# Charlotte Department of Transportation

## Memorandum

**Subject:** Rezoning Petition 08-125: Located on the southwest quadrant of Mount Holly Road and the I-485 Interchange  
(Revised 9/17/08)

SHEET NO.  
**TDS-2**

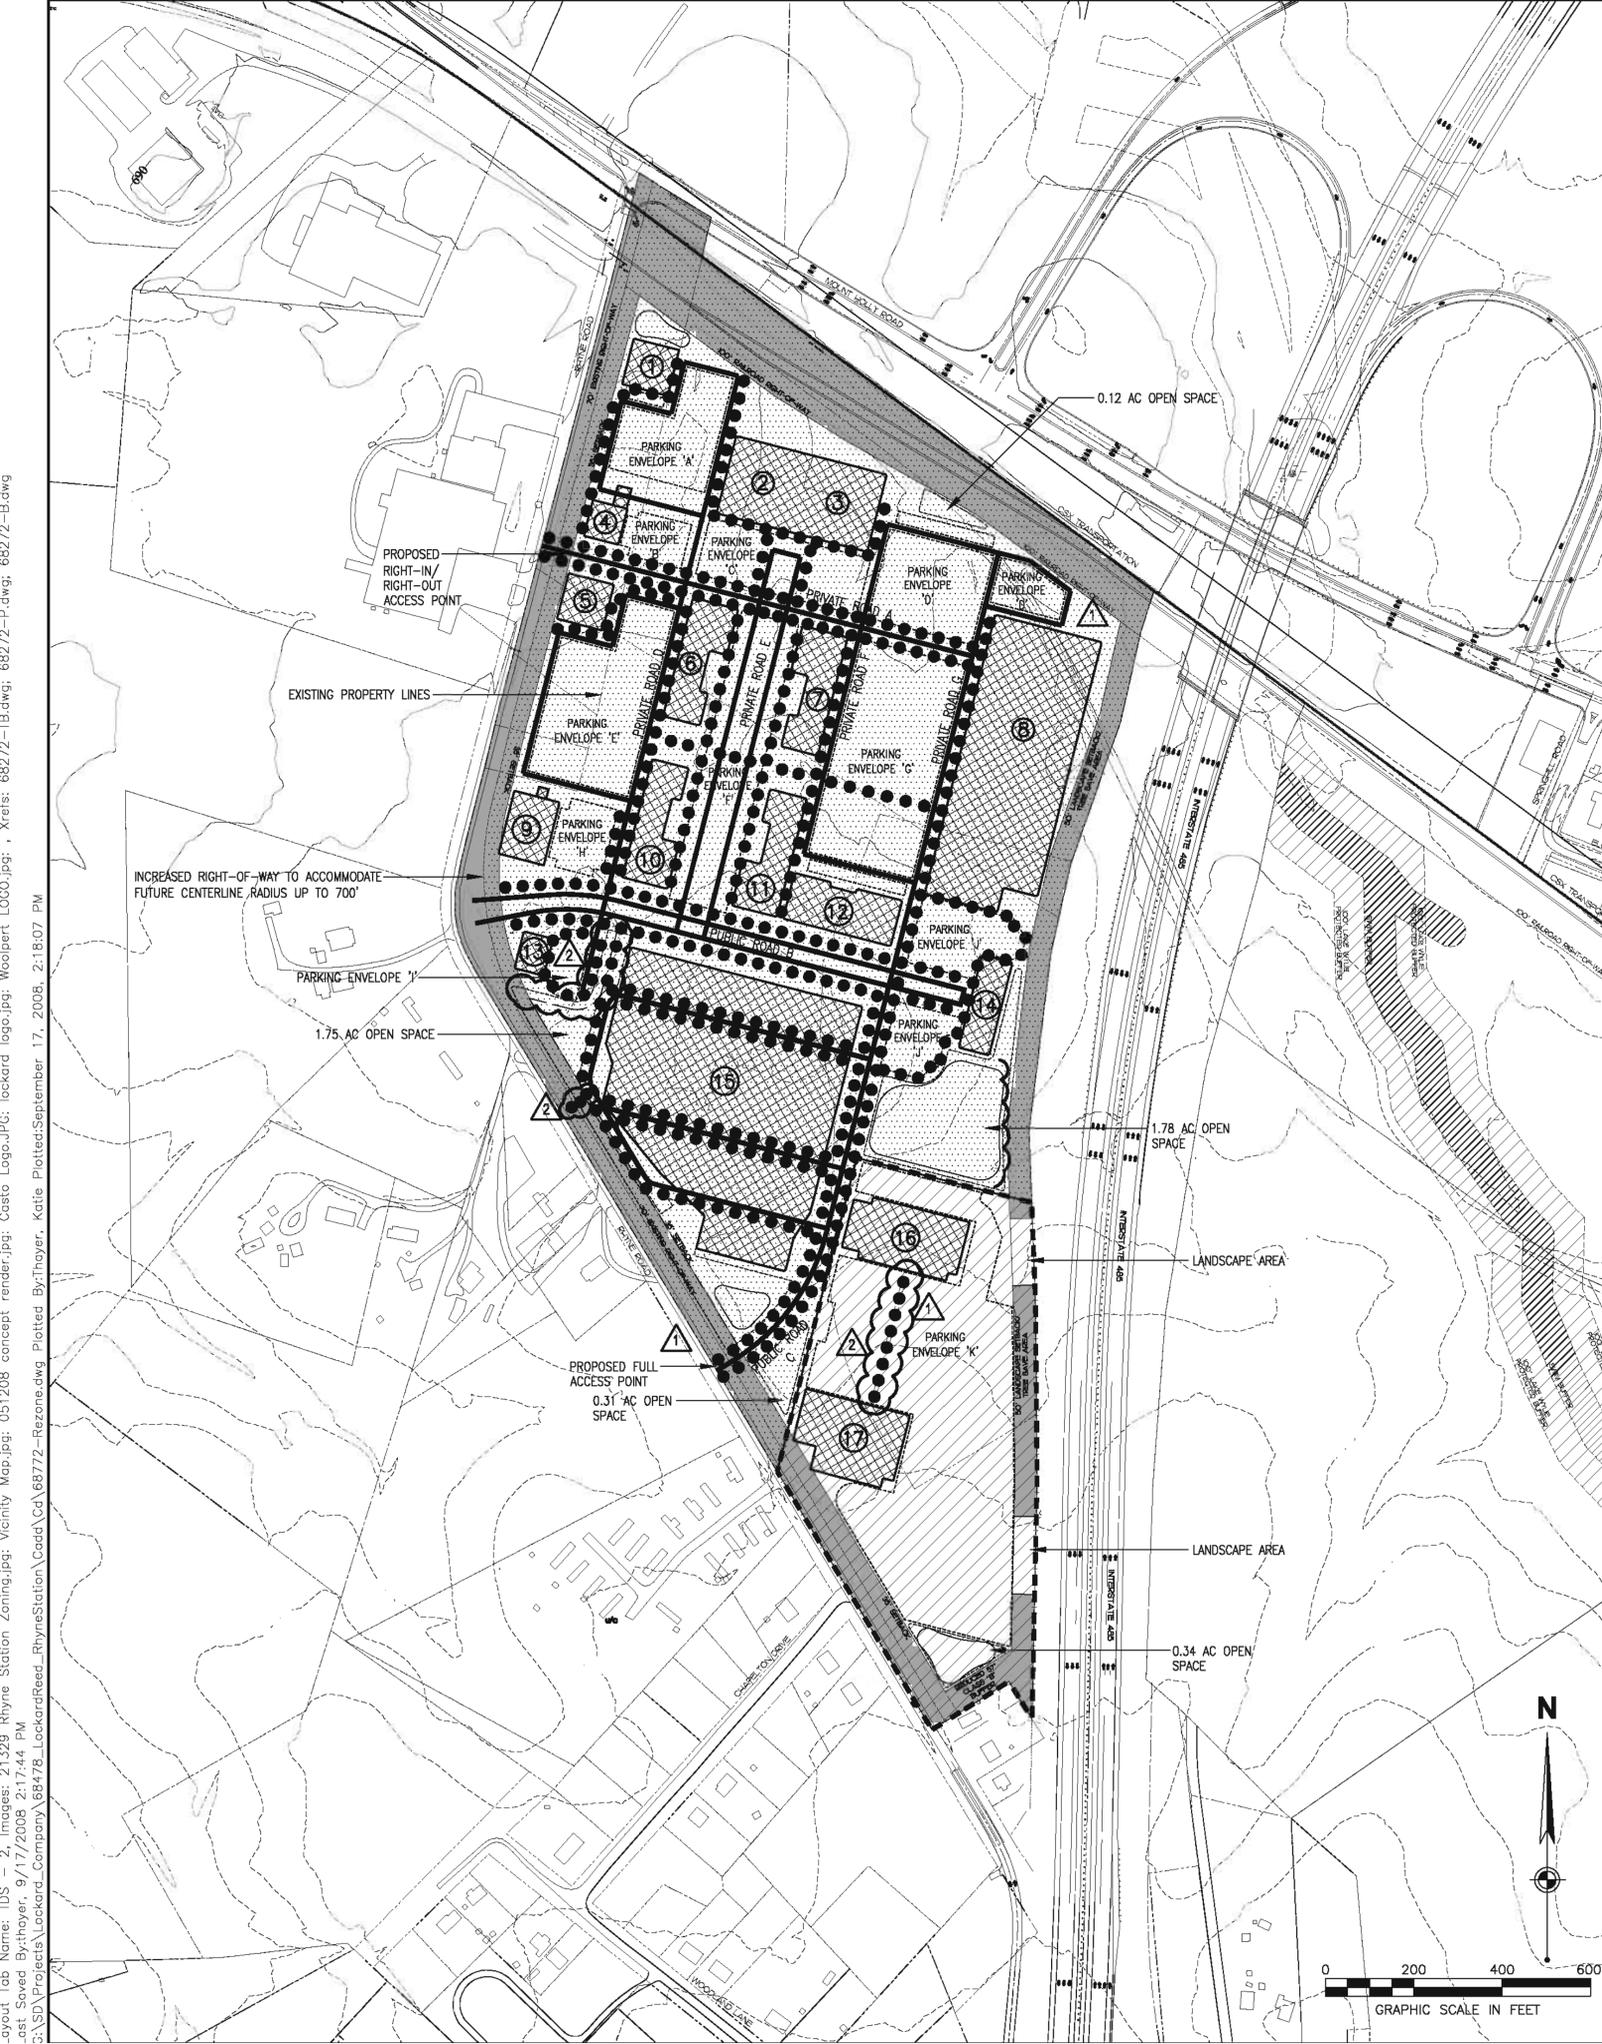
1. Development phasing/improvement thresholds for transportation improvements need to match what has already been approved under the current CD plan (rezoning 2005-150). CDOT does not support increasing the thresholds without a revised traffic study evaluation to justify the changes. (*2 Previous review comments*)
2. All streets interior to the site, including private streets, must have the 8-foot sidewalk and 8-foot planting strip on both sides of the street as committed to in the previously approved conditional site plan. 16-foot hardscapes with trees in tree pits may be an acceptable alternative in certain circumstances. (*2 Previous review comments*)
3. All public streets need to be designed as Office/Commercial Wide streets in conformance with the *Urban Street Design Guidelines* (USDG). (*Previous review comment*)

1. To better accommodate pedestrians, the townhomes need to be alley-loaded instead of front-loaded.
